CITY OF ALBUQUERQUE

March 8, 2024

Re: Circle K
10850 Golf Course Rd. NW
Traffic Circulation Layout
Engineer's Stamp 03-01-24 (A12-D008B1)

TRAFFIC CIRCULATION
LAYOUT APPROVED

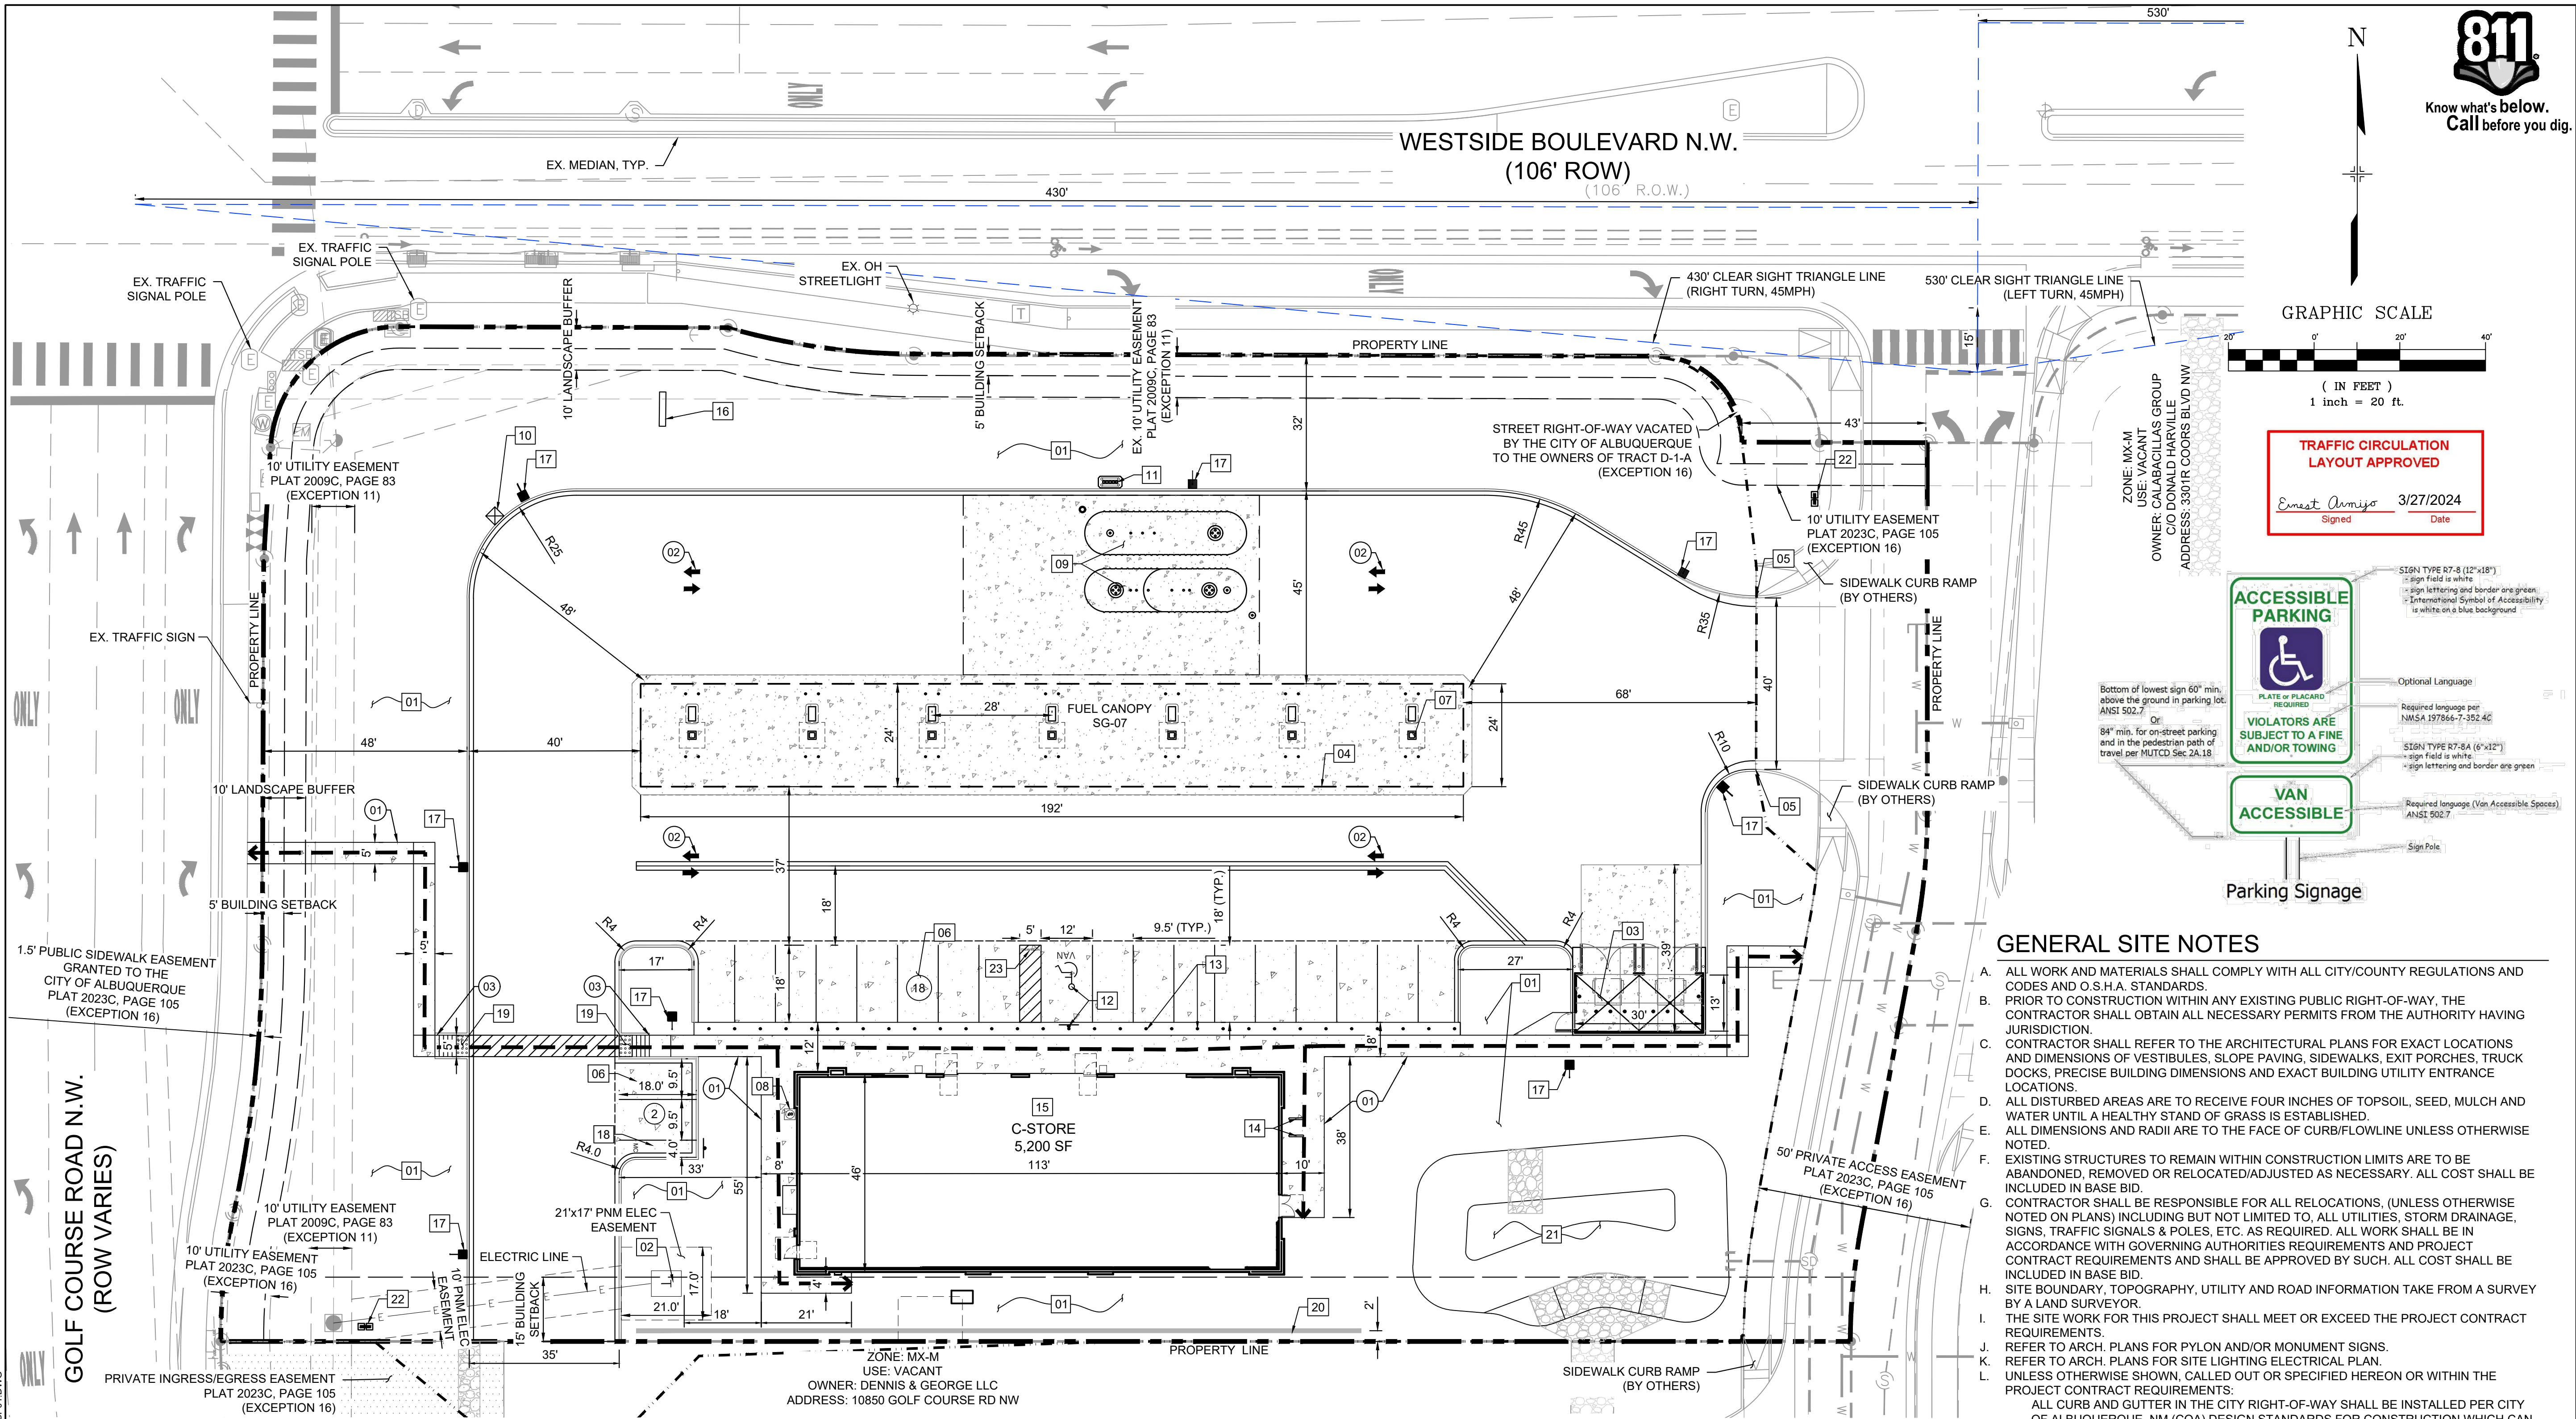
1. Please show a vicinity map showing the location of the development in relation to streets and well-known landmarks.
2. List the number of parking spaces required by the IDO as well as the proposed number of parking spaces including bicycle and motorcycle parking.
3. Identify all existing access easements and rights of way width dimensions.
4. The ADA access aisles shall have the words **"NO PARKING"** in capital letters, each of which shall be at least one foot high and at least two inches wide, placed at the rear of the parking space so as to be close to where an adjacent vehicle's rear tire would be placed. (66-1-4.1. B NMSA 1978)
5. Provide details for the proposed interior ramps and sidewalk.

6. Show the Intersection clear sight triangle at the site access off Westside Blvd.
7. Provide a copy of approved recorded plat.
8. Provide a copy of Fire Marshal and Solid Waste approval.
9. An approved TIS is required prior to approve the TCL for building permit.
10. Please provide a letter of response for all comments given.
